From: Zac Denton
Sent: 20 December 2018 08:43
To: Lynnyrd Wolfe
Subject: FW: Ep/166/18/hh
Attachments: 18075 DOYLE 100 Sea Road East Preston new-01R1 EXISTING A1.pdf; 18075 DOYLE 100 Sea Road East Preston new-02R3 PROPOSED A1.pdf

From: kathryn [REDACTED]
Sent: 14 December 2018 10:57
To: Zac Denton
Subject: Ep/166/18/hh

Proposed Floor Plans,
Elevations, Roof Plan and
Block Plan

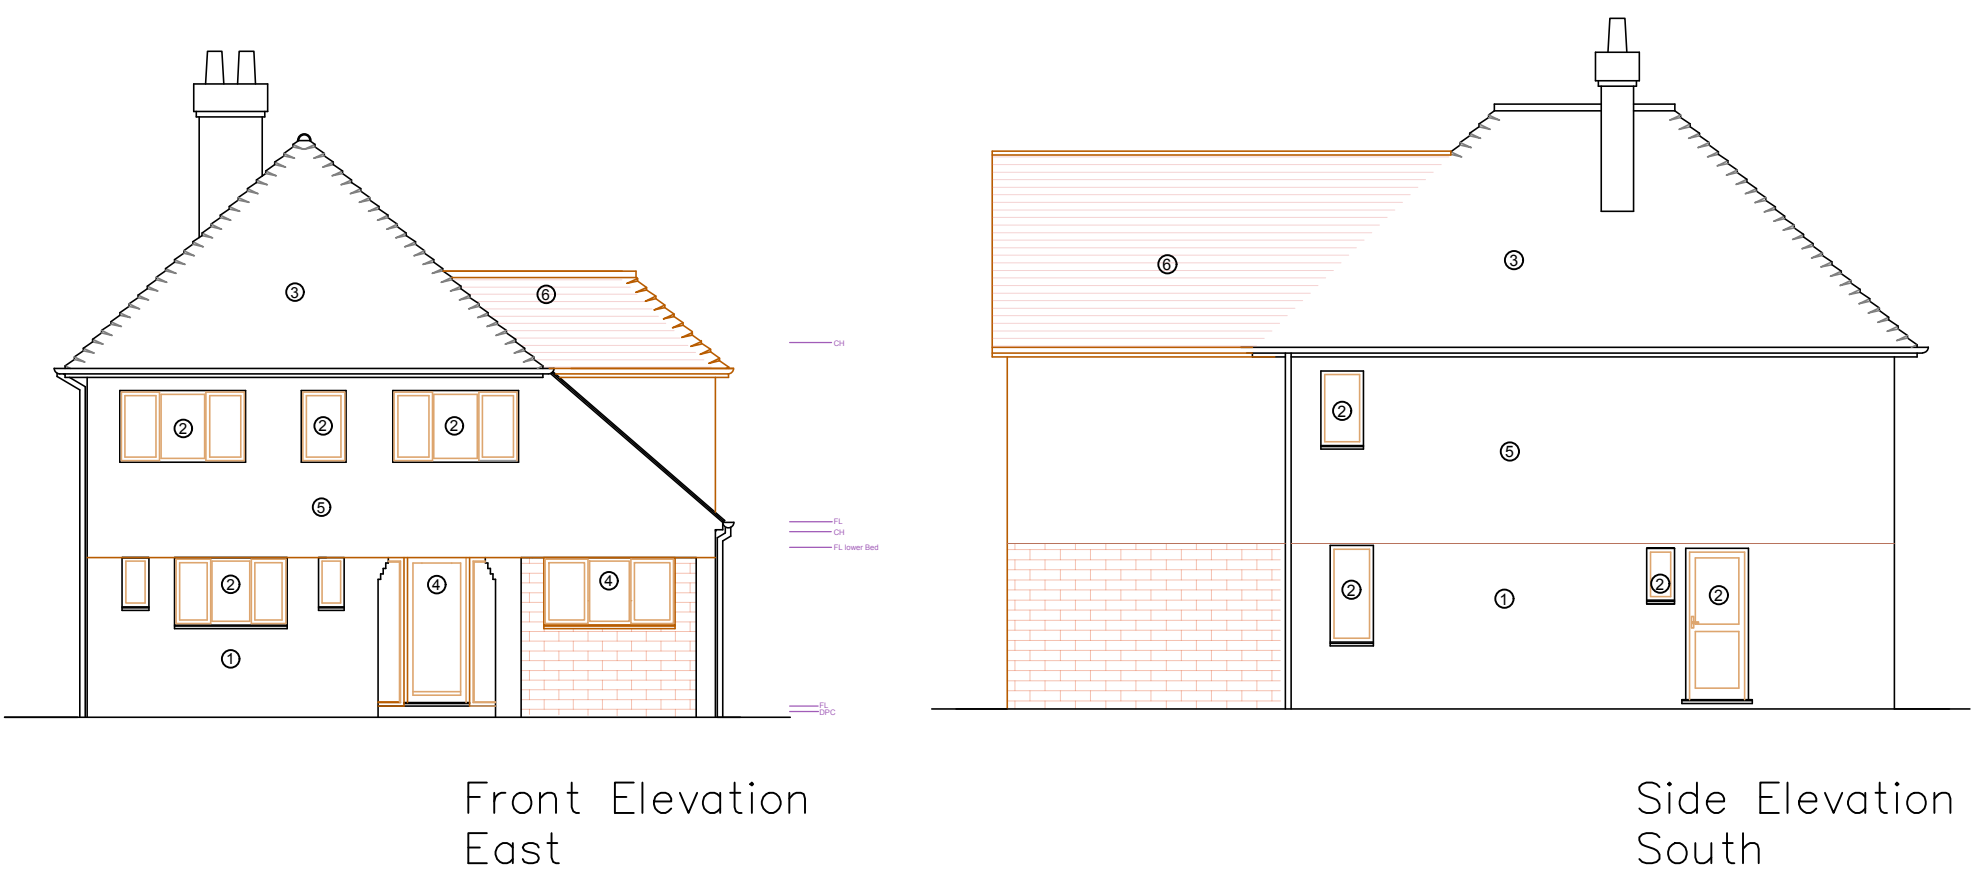
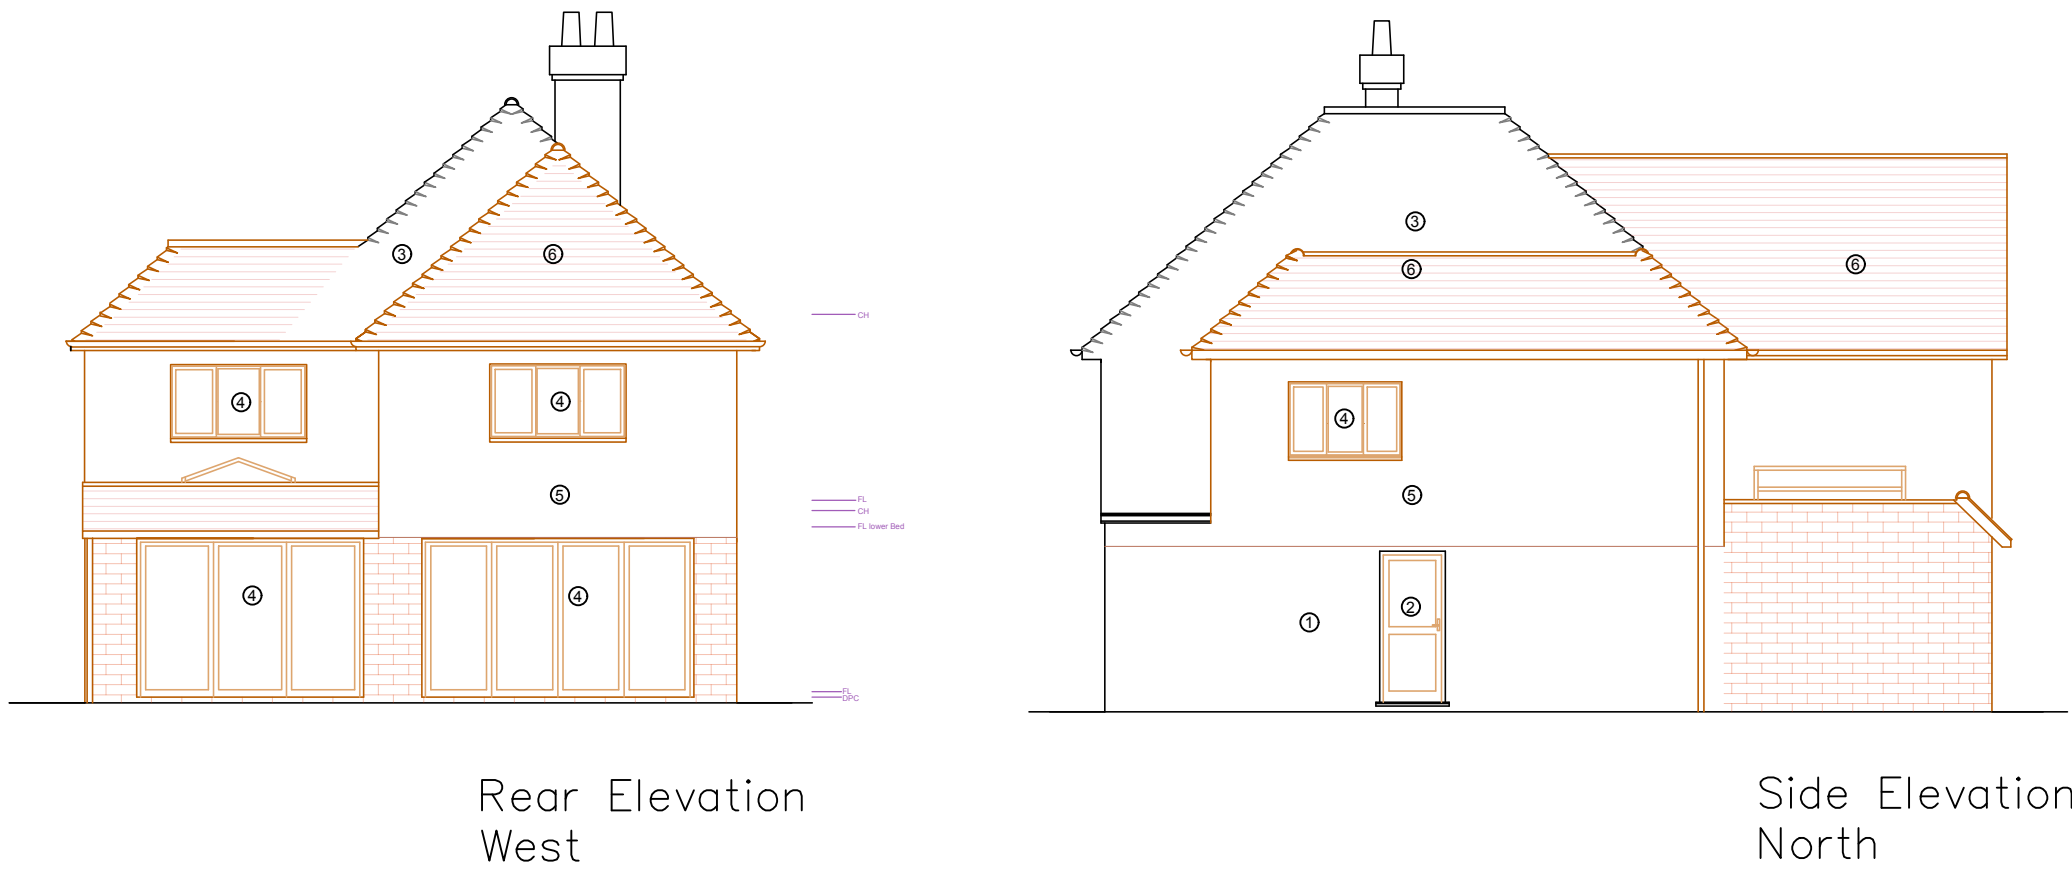
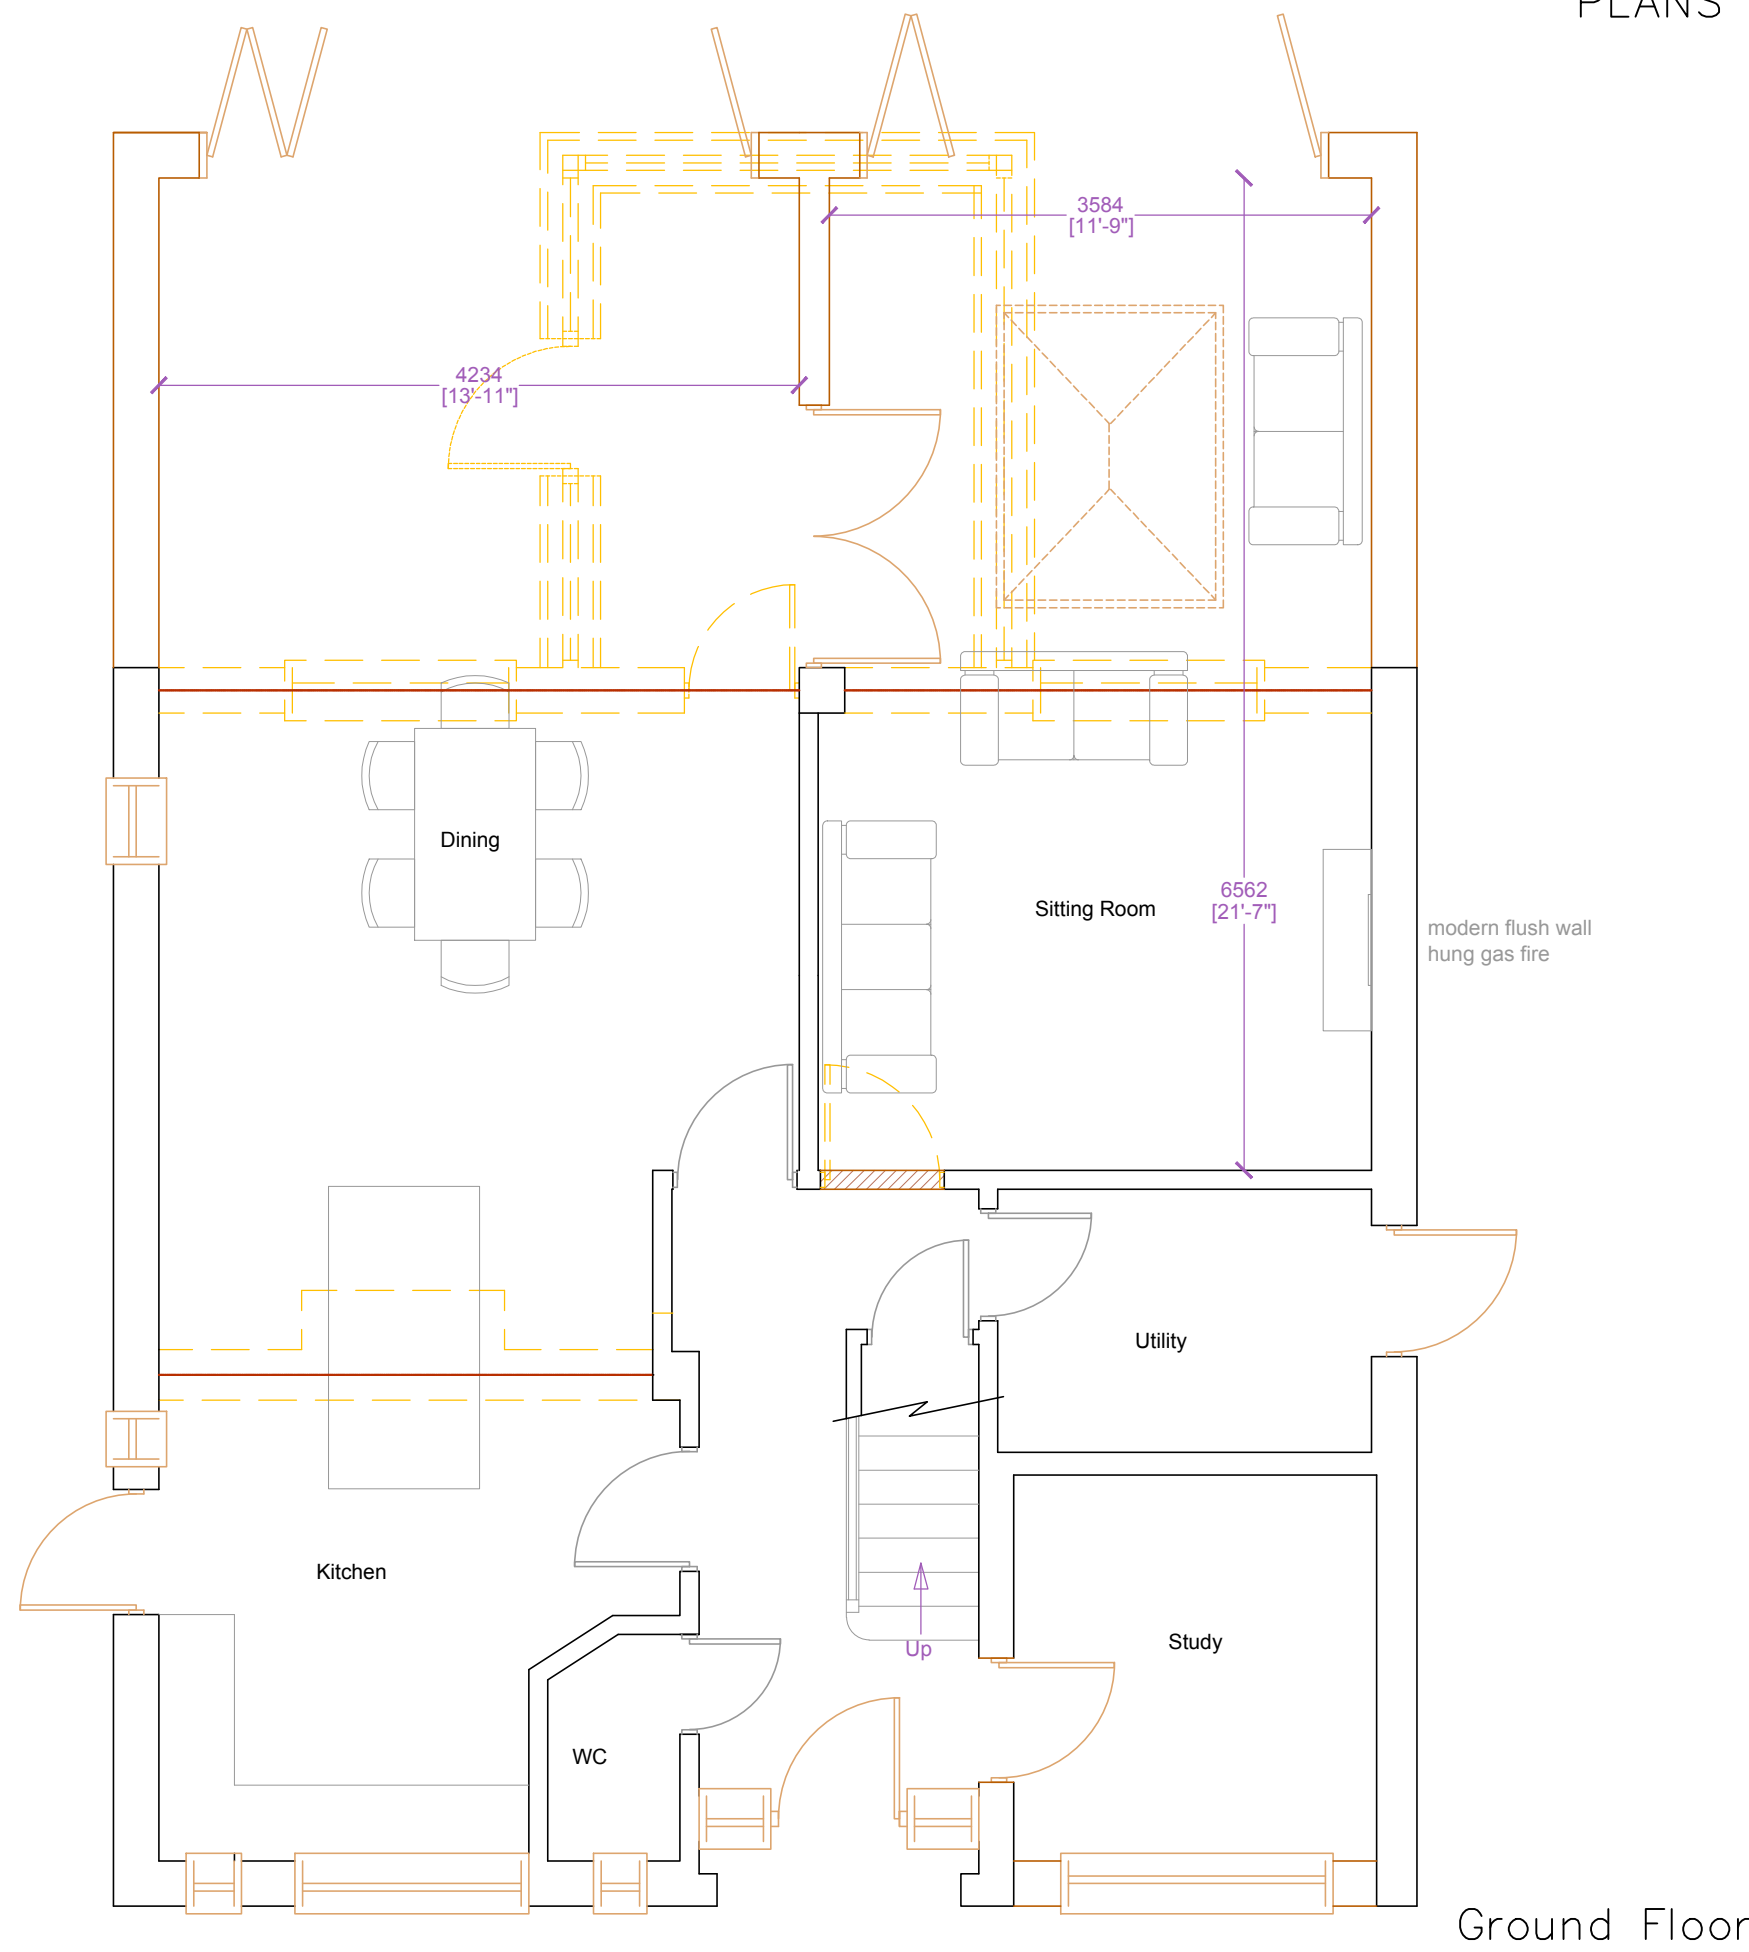
Further to our recent telephone conversation please find attached the amended plans detailing the change in labelling.

May I also take this opportunity to respond to comments from the neighbouring property at 102 Sea Road. The proposed 2 storey extension will as stated in the comments extend past the rear of the house by 3.5 m however this is no further than the existing conservatory extends within the garden of 100 Sea Road, or indeed various other conservatory/extension along that stretch of road. The proposal comfortably sits within the 45 degree rule for extensions such as these.

I would also like to alleviate the neighbours fears regarding overlooking and overshadowing; there are to be no overlooking windows on the Southern elevation of the proposal, equally due to the application site being set further North of 102 Sea Road, there won't be any issue of overshadowing. Their current dining area and utility room of 102 Sea Road can only ever be overshadowed by their own property.
